Your Ref: OWPC23746
Our Ref: K/19/19/HH 25-06-2019
Please ask for:
Zac Denton

Two storey rear extension with a small canopy projecting the footprint to the front.
Demolition of existing living room and additional first floor for habitable use with alterations to fenestration.

Little Tangle Middle Way Kingston Gorse East Preston

Thank you for your internet representation made on 23rd July 2019 which has been recorded as '**an objection**' with the comments as follows:

Drawing Title
**Existing and Proposed
Floor Plans**

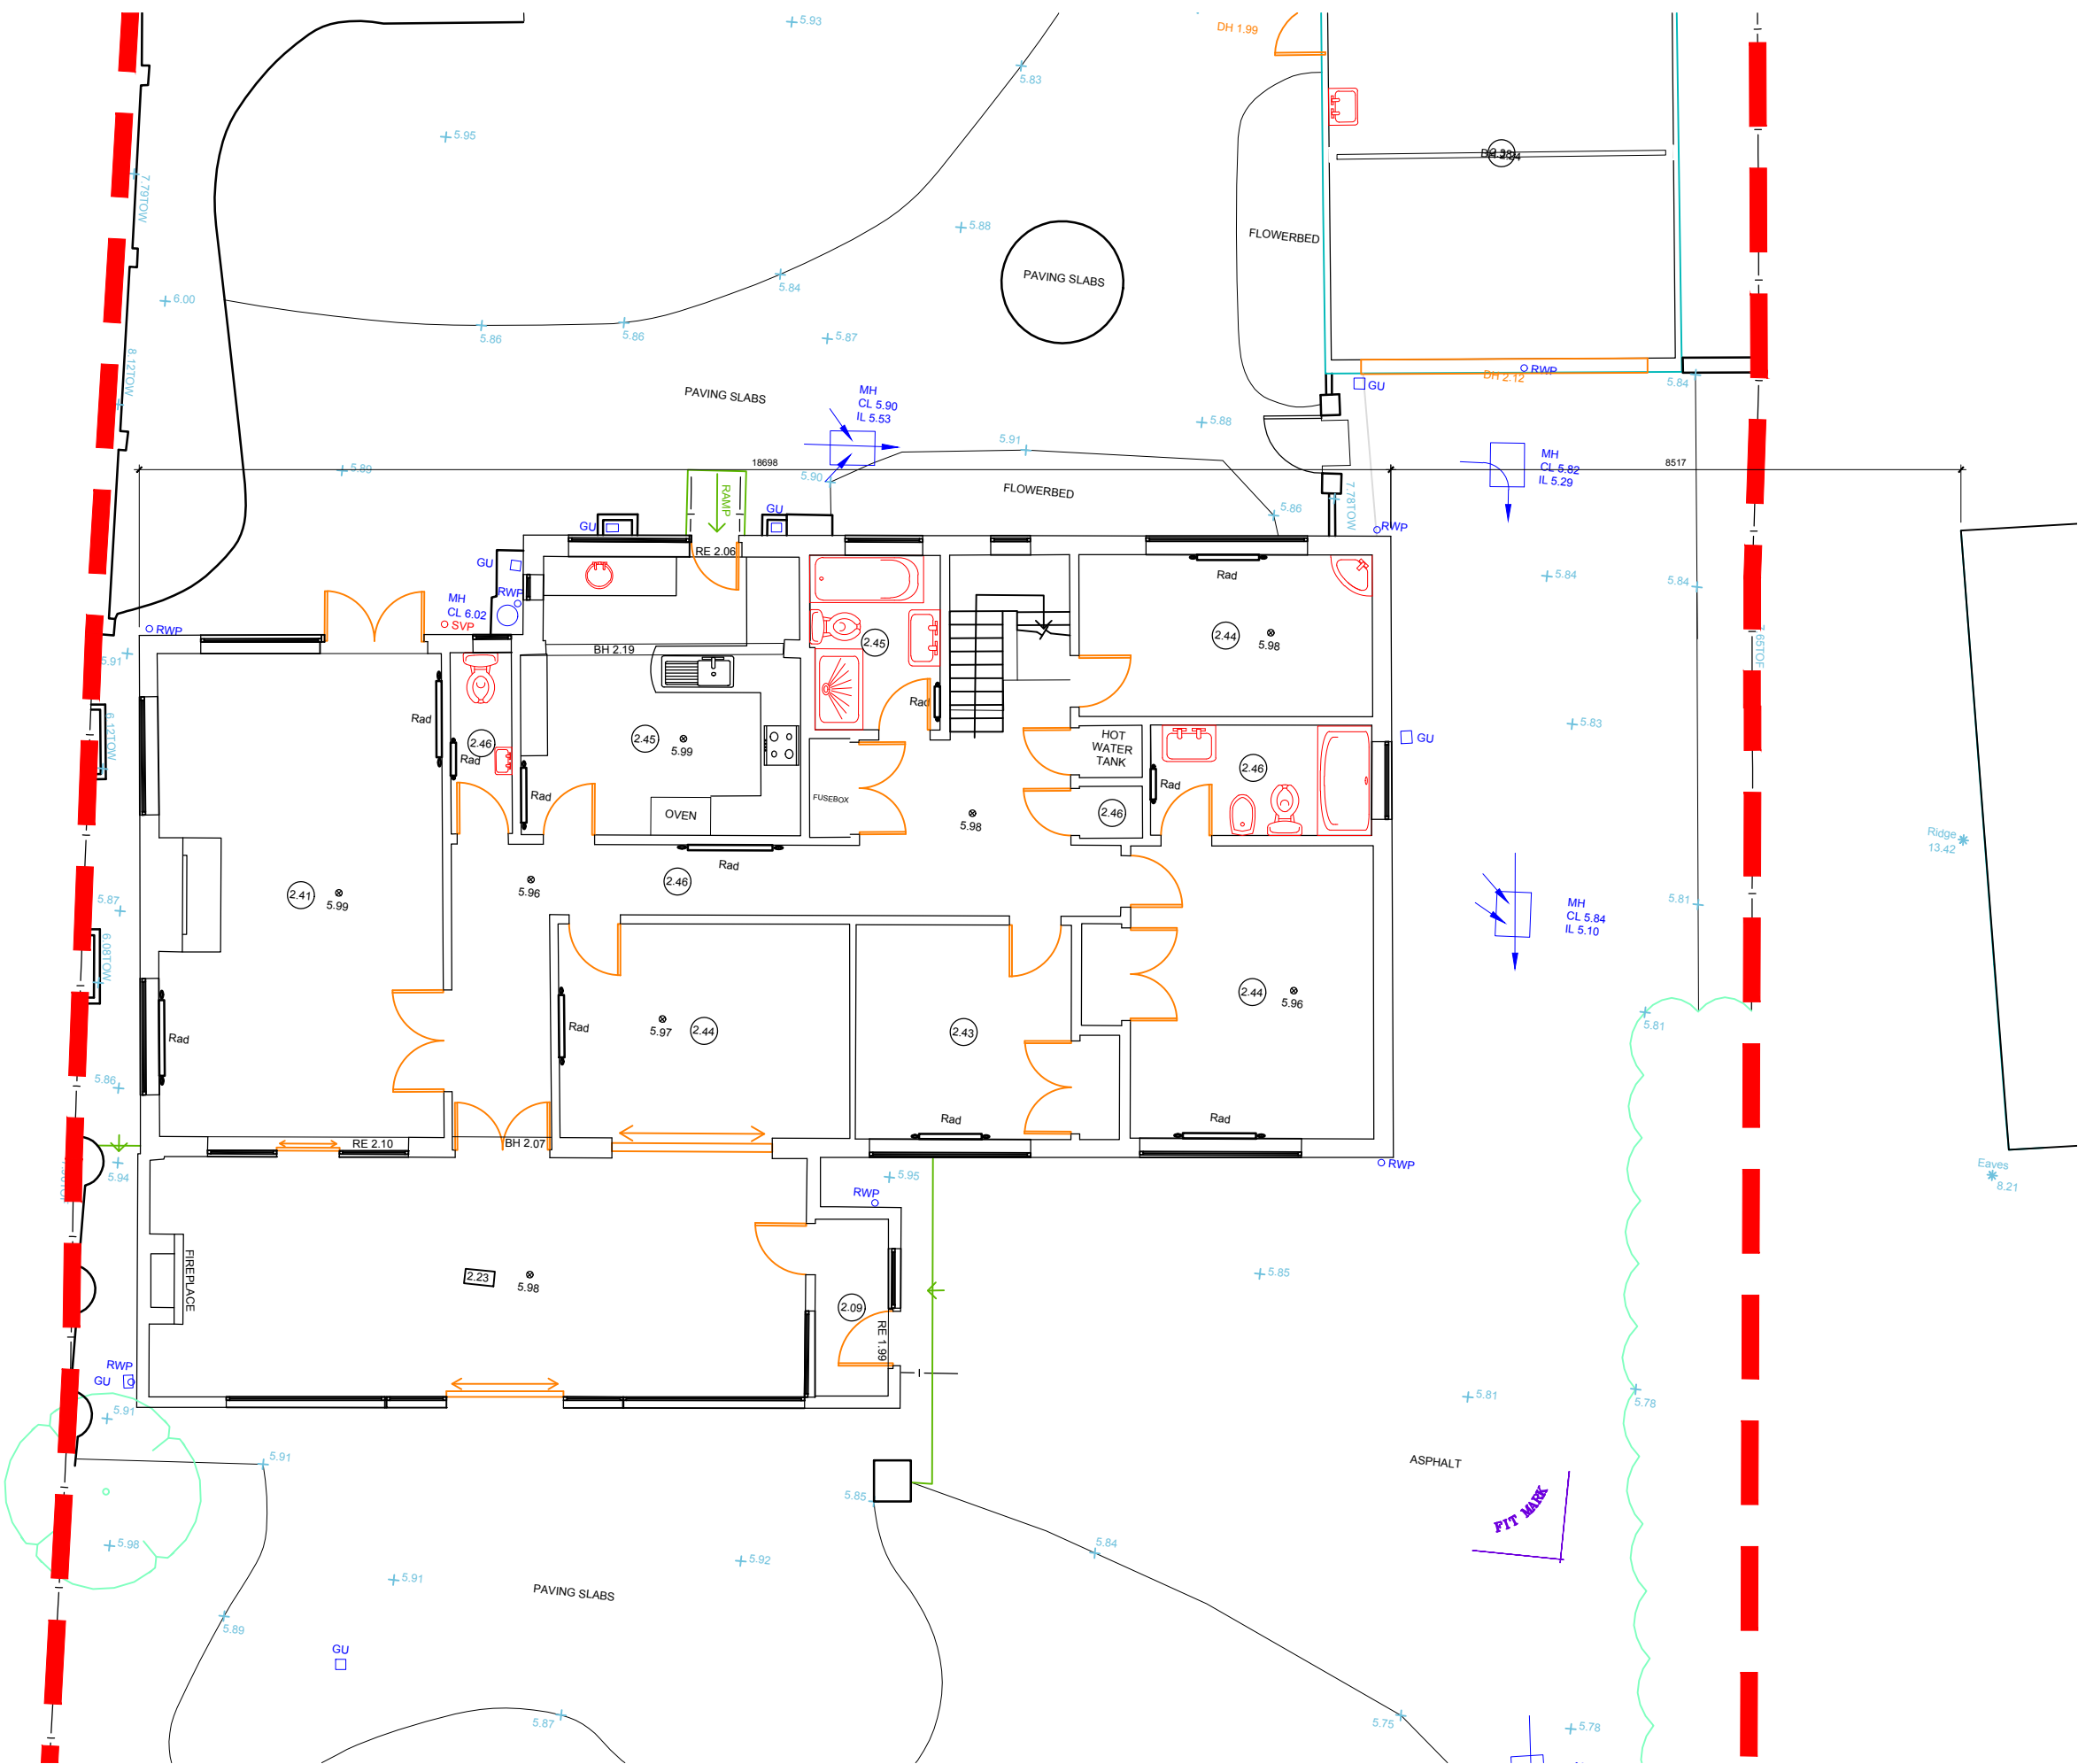
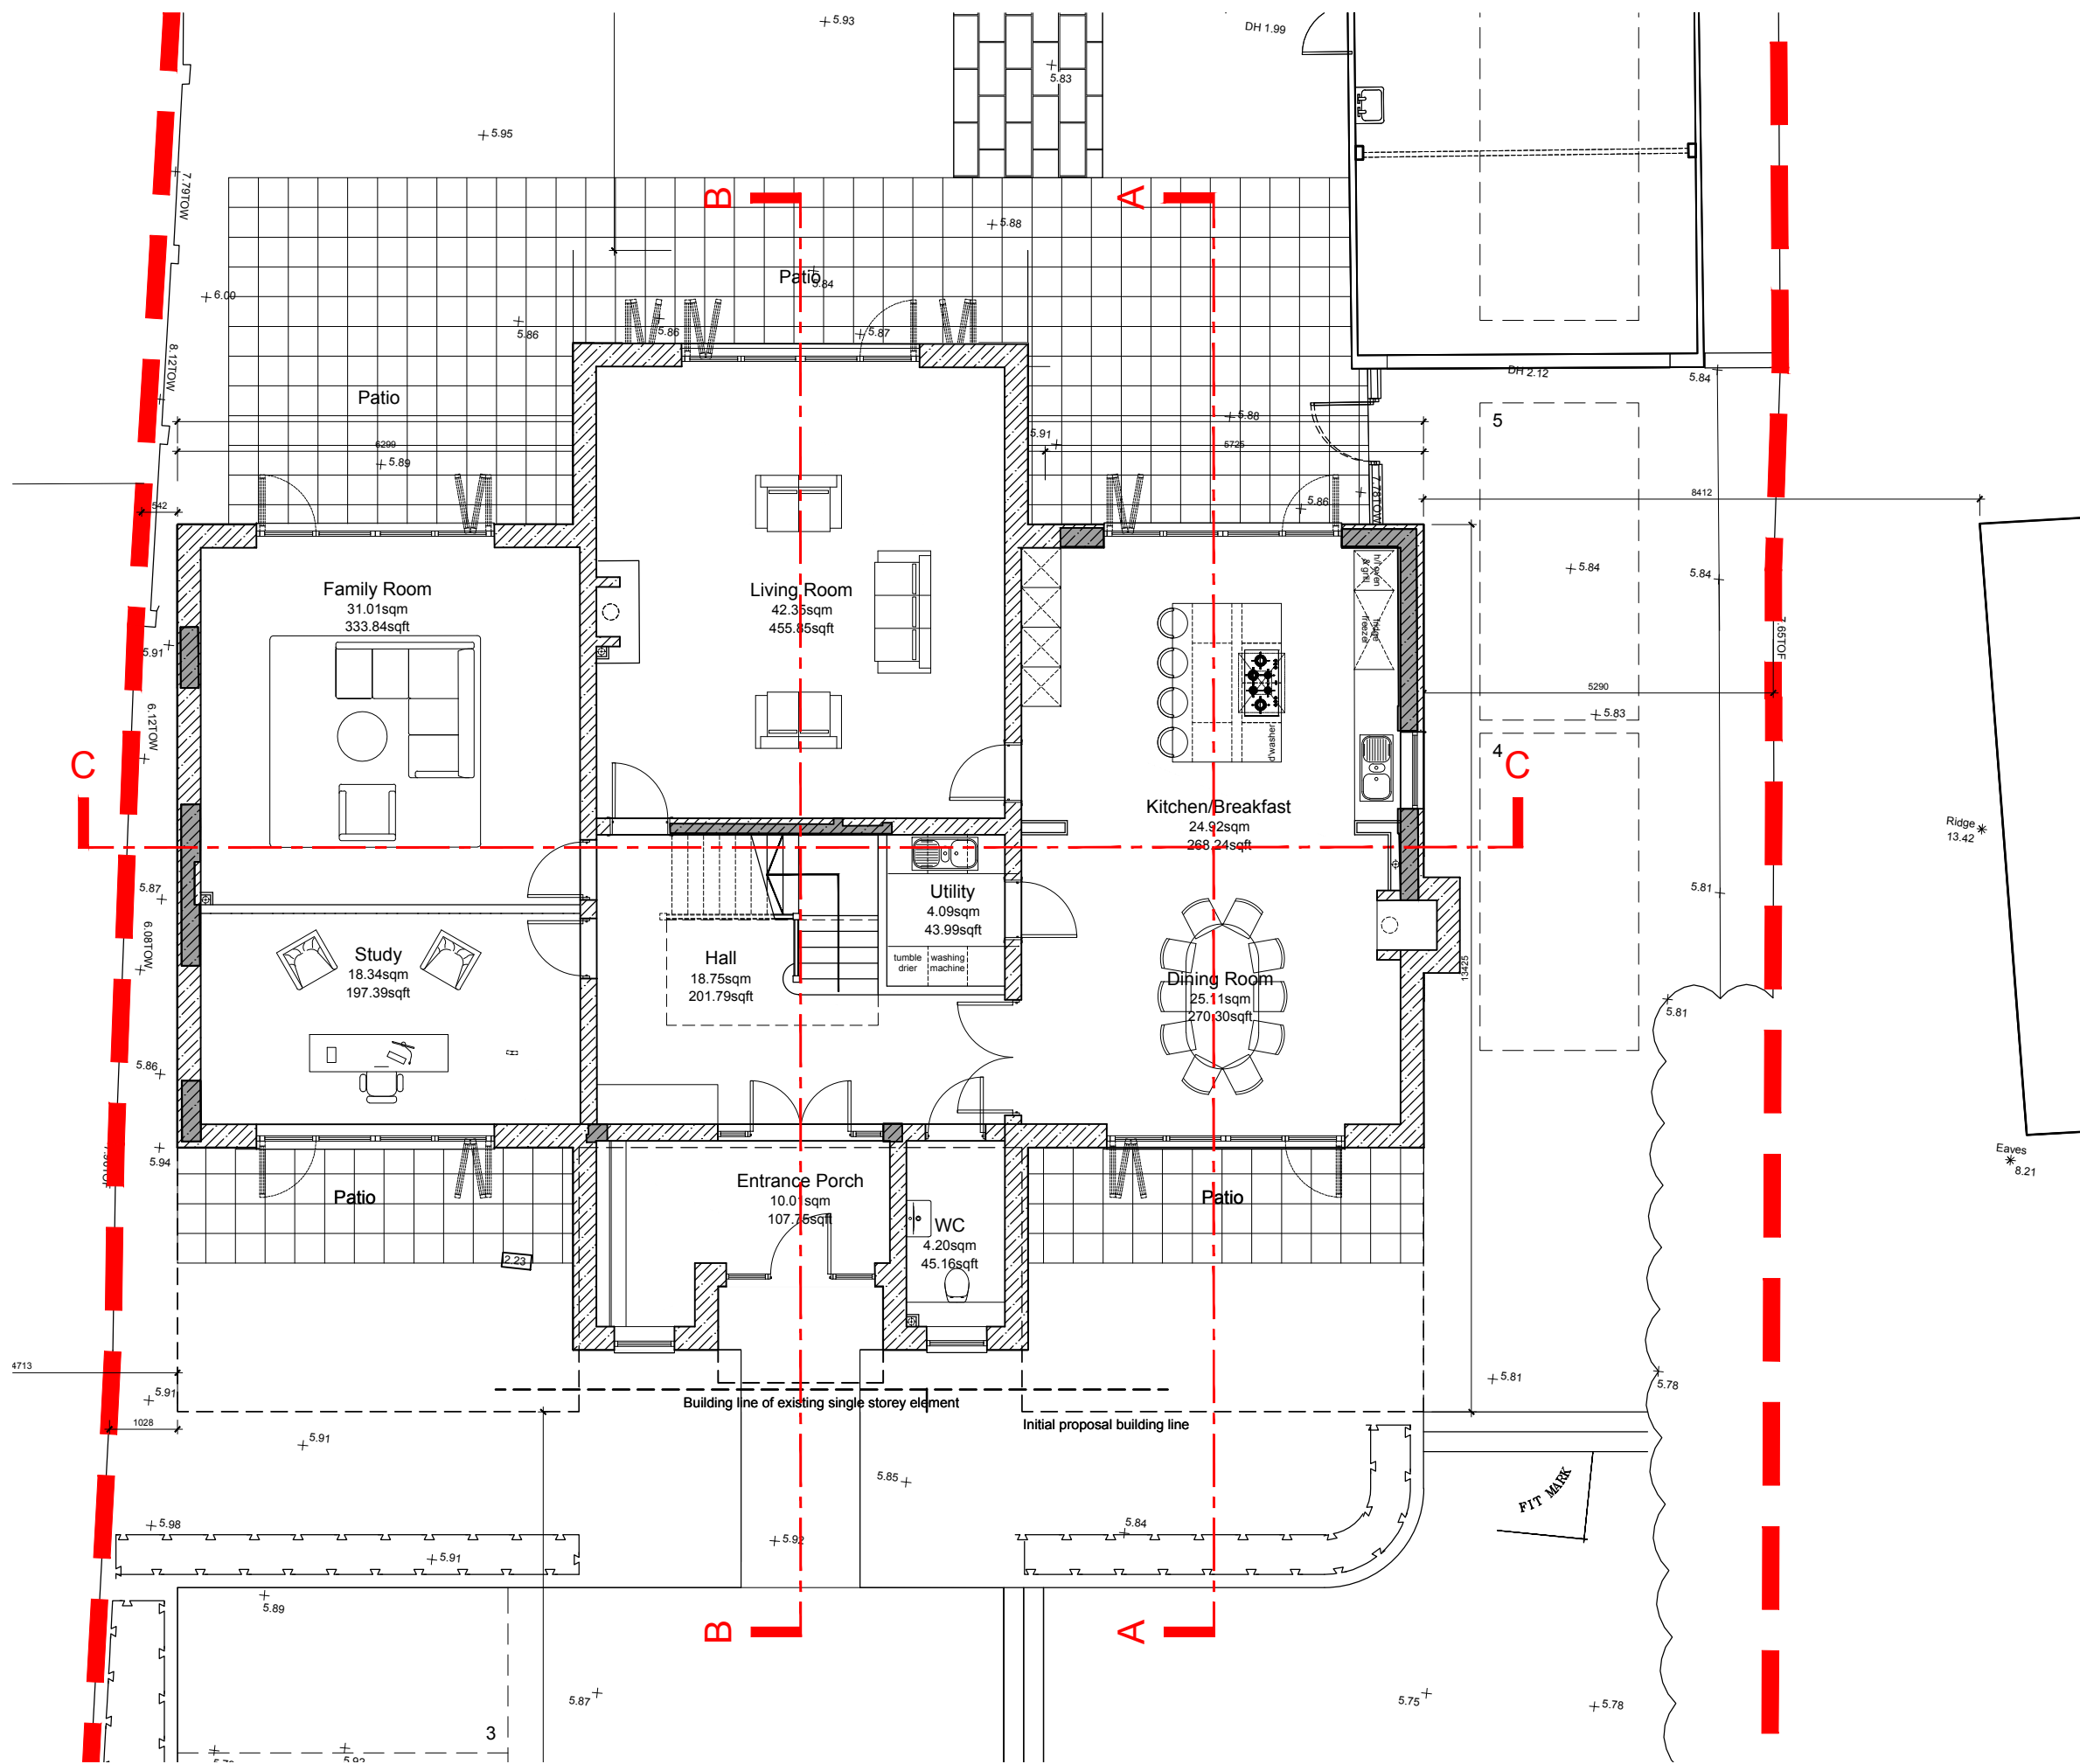
1. Little Tangle is a bungalow, with a room in a small part of the roof rather than a detached house. The application maintains the overall m2 on the ground floor but it increases the overall building mass by over 200% due to the 1st floor changes.

3. The ground floor m2 footprint is unchanged but the shape of the footprint is different. The proposed rear development extends the footprint beyond the current building line and that of The Poynings. It would be a 2-storey extension 3.4m higher than it is today and 2m higher than The Poynings.

4. There is to be a window on the ground floor east elevation. One exists today but it is small, opaque and virtually invisible due to the height of the side fencing. It is unclear from the drawings if this is to be maintained or changed in anyway i.e. size, glass type etc. We are assuming any planning approval would require the current level of privacy to be maintained.
